BN15/9000

**Tomingley Gold Mine – Modification 3 (09_0155 MOD 3)
Review of Environmental Assessment**

NSW Department of Industry, Division of Resources & Energy (the Division) has reviewed the Tomingley Gold Mine Environmental Assessment, November 2015.

Figure 2.1
MINE SITE LAYOUT

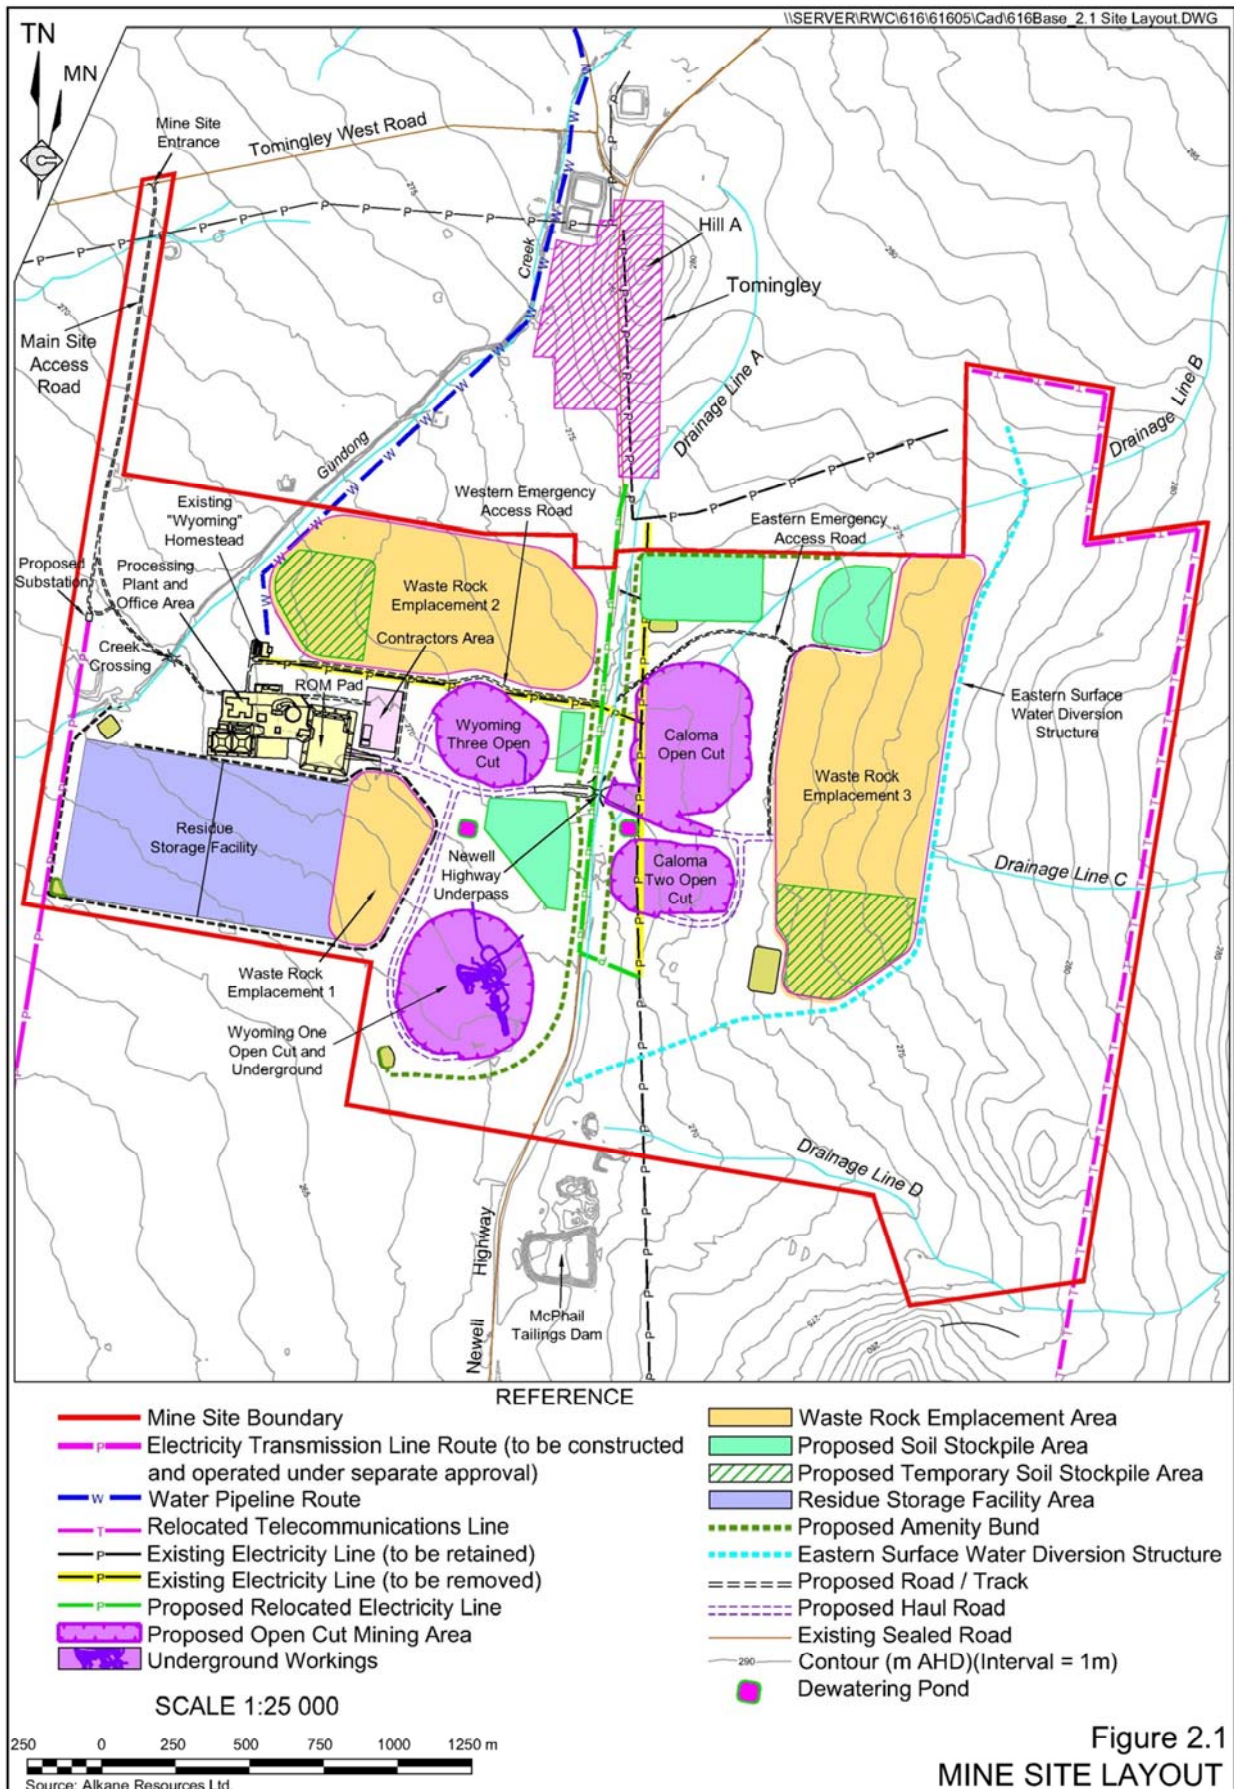
Given the current and planned open cut and underground operations for the Project should optimise resource recovery, the Division seeks further information on the proposed exploration to adequately assess potential resources at depth below the targeted resources within the Caloma 2 open cut.

The Division also recommends that consideration be given in the mine plan to backfill of the Caloma 2 void. Prior to the completion of the Caloma 2 open cut in mid-2018 the proponent should provide clear justification for not emplacing waste rock in the Caloma 2 void.
